Application for a Non-Material Amendment Following a Grant of Planning Permission

New activity hall and front entrance to the school, with the existing spaces being internally remodelled to provided much needed classroom and teaching facilities as well as staff facilities such as offices

23/03671/FUL

Non-Material Amendment(s) Sought

PROJECT: North Cambridge Academy	DRAWING: Proposed Elevations
CLIENT: Meridian Trust	DRAWING NO.: 23 4481 ZZ DR 4 21 250 SCALE: A1 @ 1:100 REVISION: <input checked="" type="checkbox"/> SCALE: A3 @ 1:200 Date: Oct 2023
DRAWN BY: G Howson	CHECKED BY:

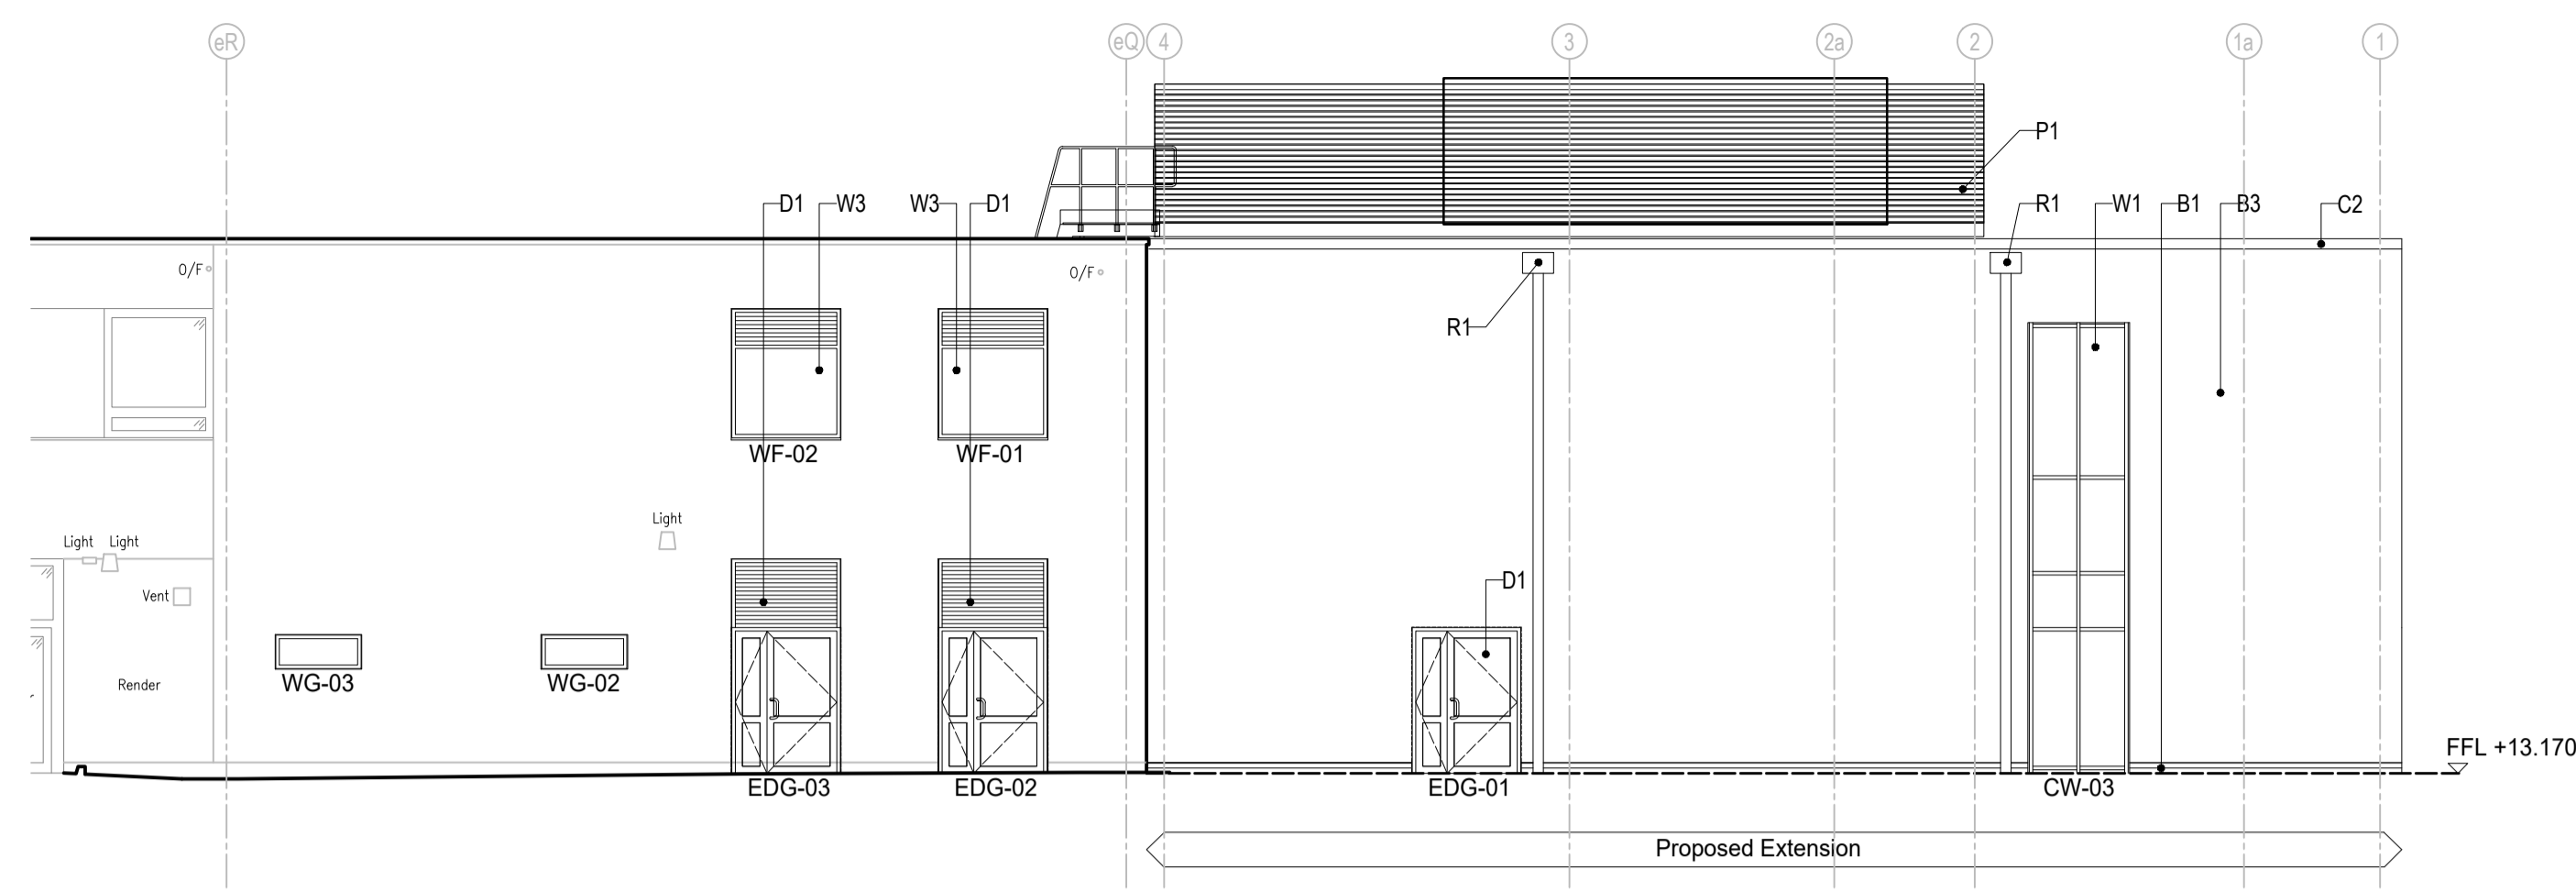
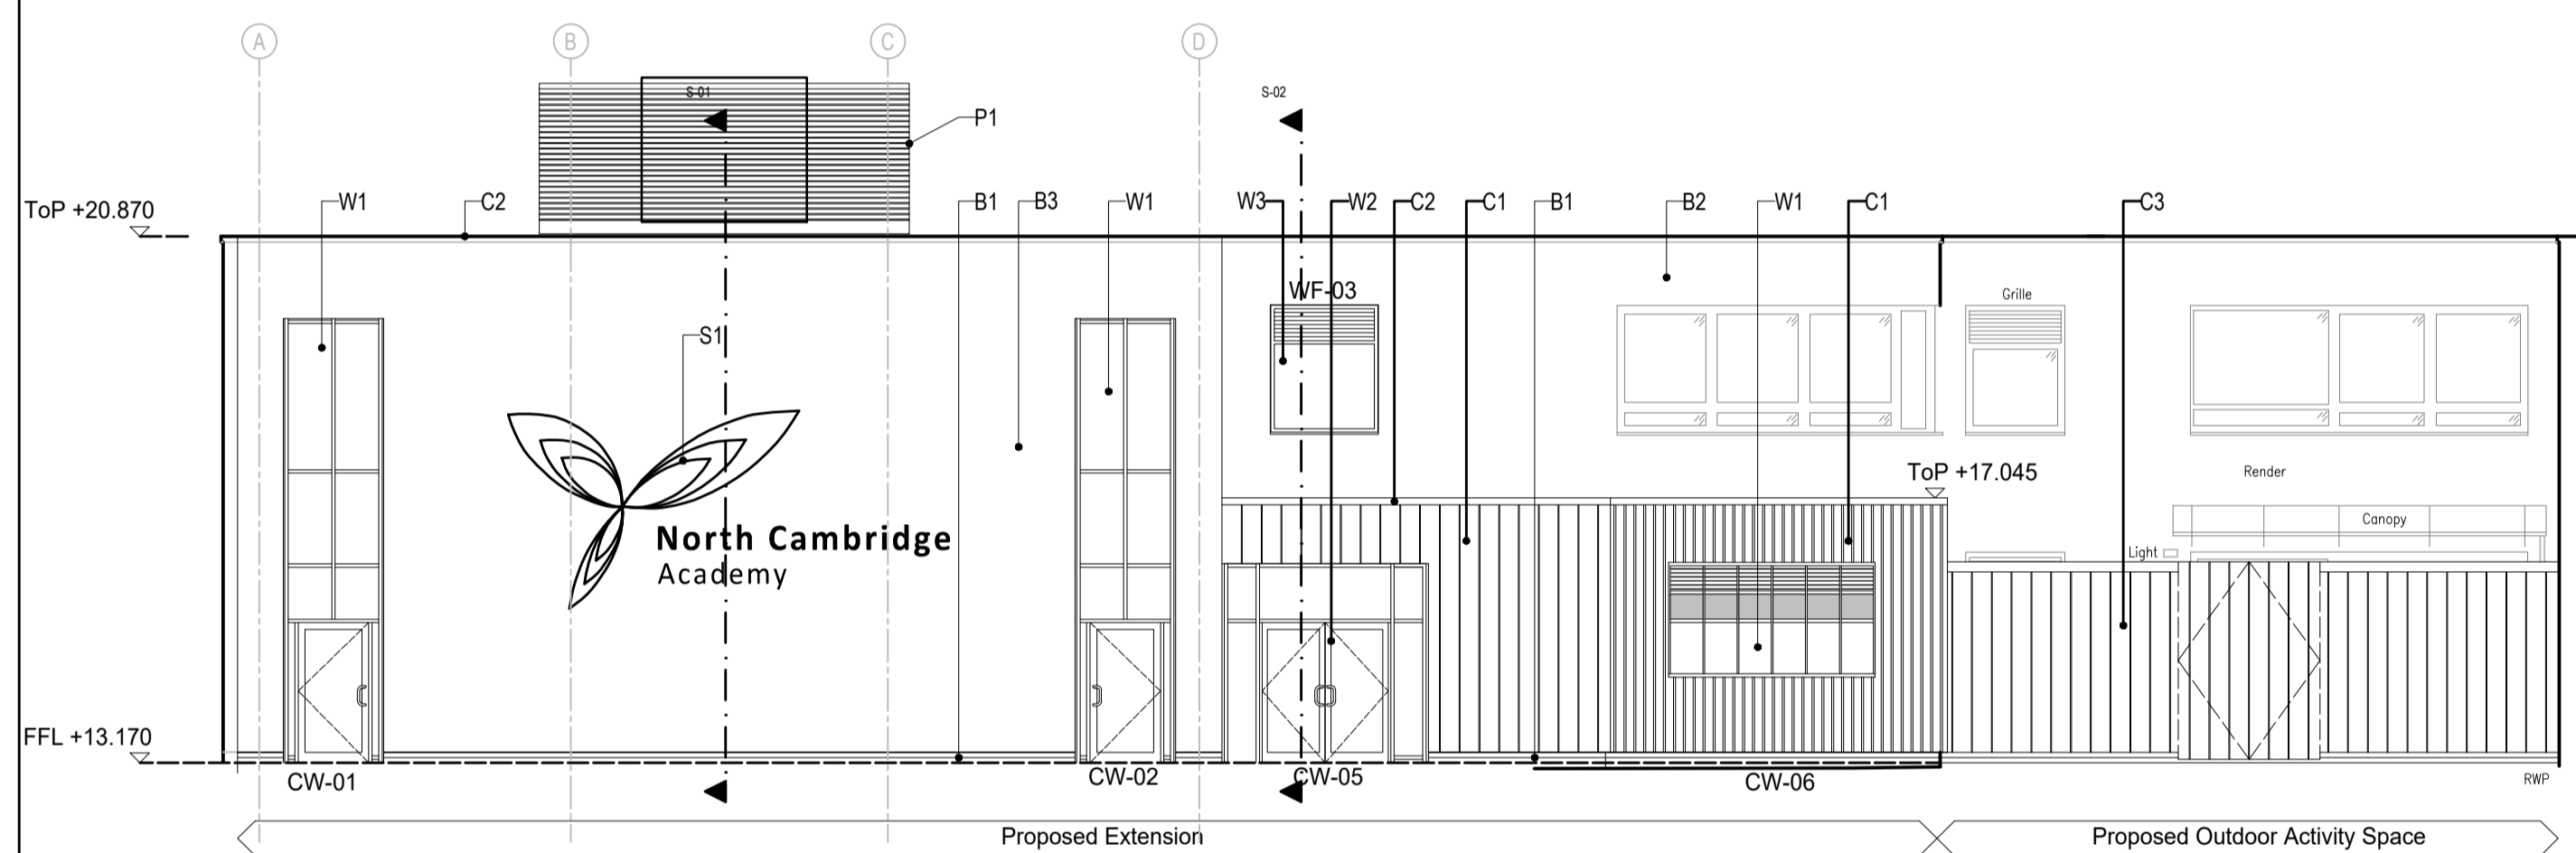
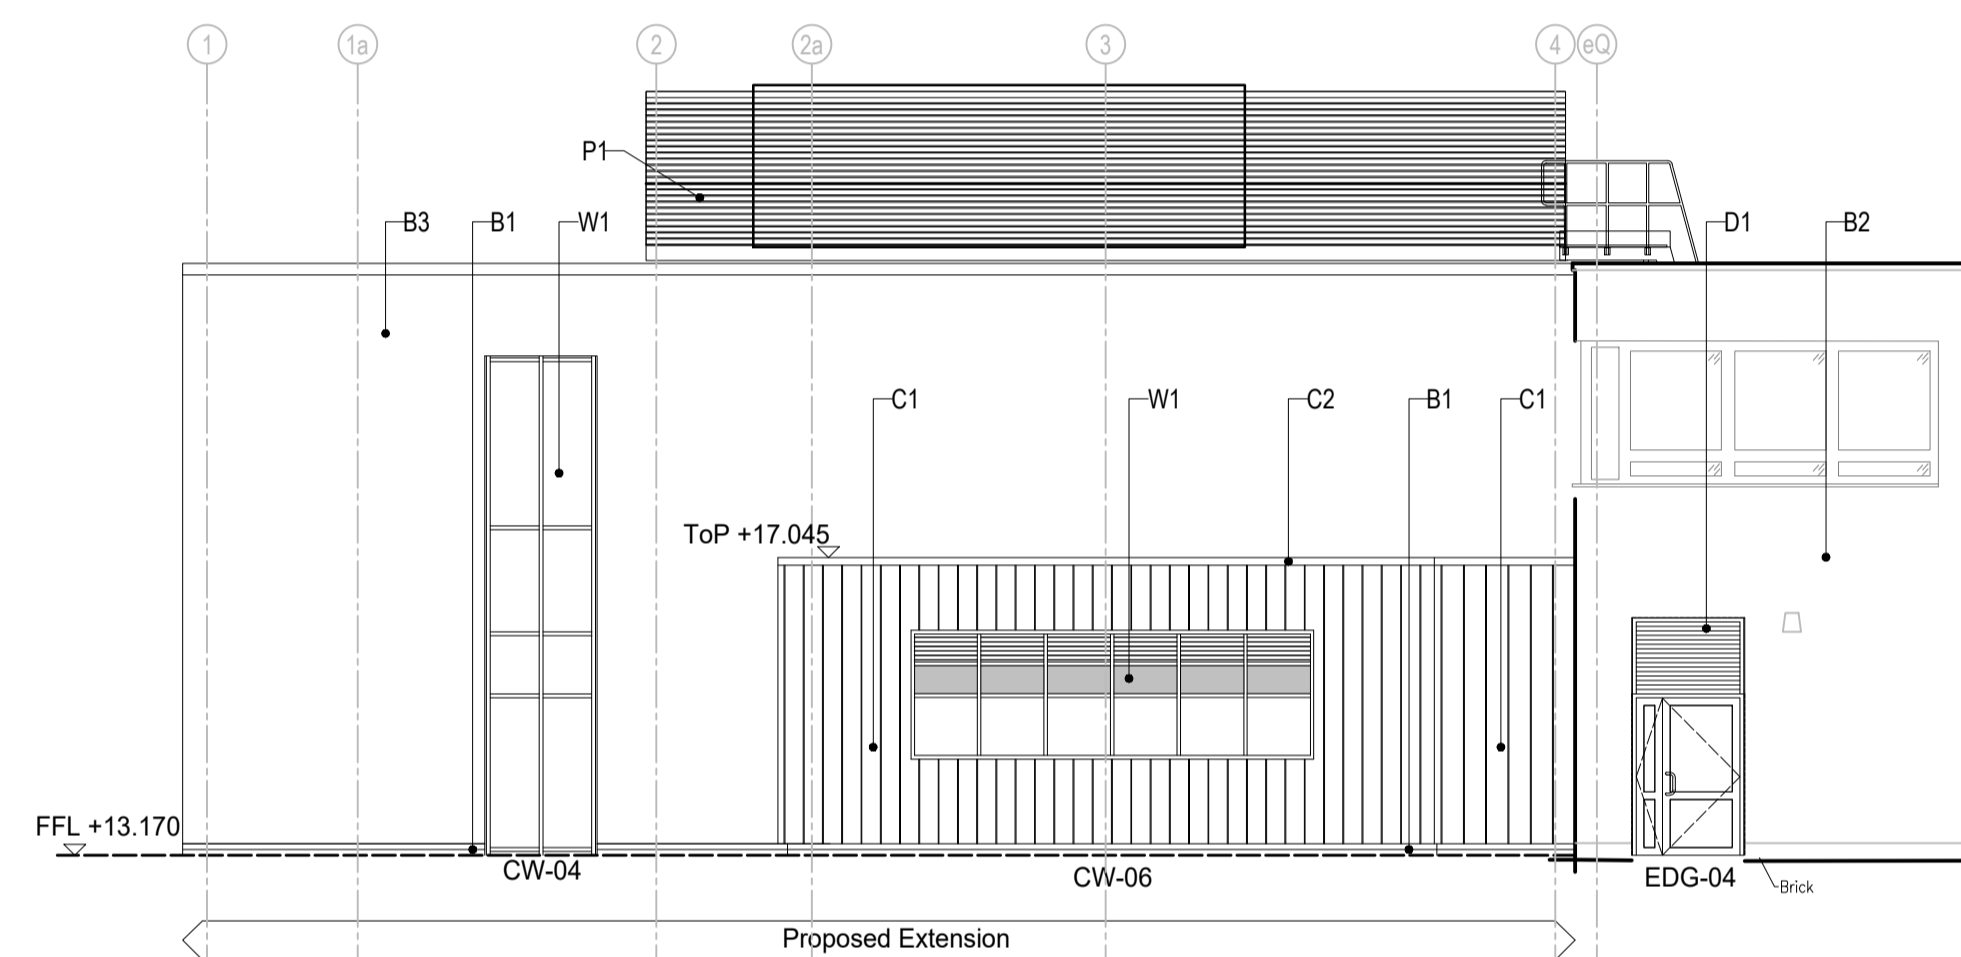
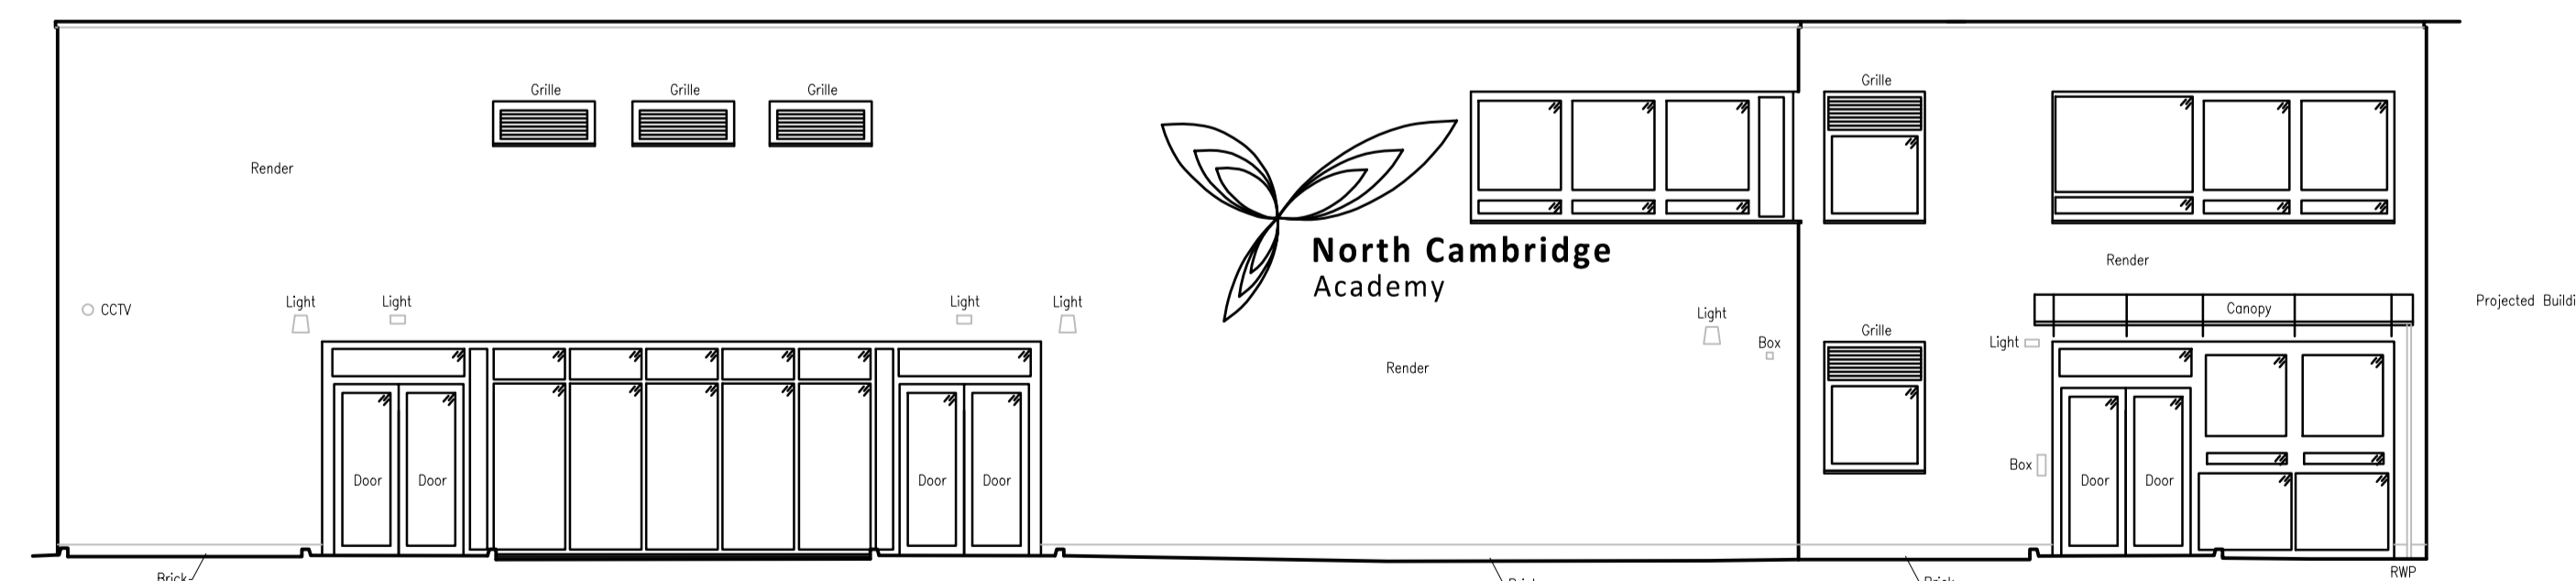
We are looking to change the material treatment to the new extension and remove the metal fins originally proposed. The new hall would be rendered to match the existing and the new entrance emphasised using a standing seam metal cladding system - colour TBC. The plant for the new main hall has also been positioned on the roof of the extension. This was not previously shown in the application

Due to restrictions on light levels created by the fins within the new spaces alternative options with increased spacing were considered. Unfortunately it was felt that by increasing the distances between the fins this would affect the original aesthetic created by the fin design and lose its impact. It was also felt that despite the new entrance construction it was still lost at the front of the site with no clear delineation of access points. By changing the materials it allows the new entrance to be emphasized and become more prominent through the use of a standing seam cladding system. The new hall extension would then be finished in a similar material to the existing building (white render) to allow it to blend in and emphasise the vertical element of the new windows and the new entrance extension. The new plant located on the roof would be concealed using a louvered system (similar to the existing) to limit the visual impact. The plant is also stepped back from the front of the building to the rear of the new roof to help conceal it.

23 4481_ZZ_DR_4_21_250 Rev_C Proposed elevations
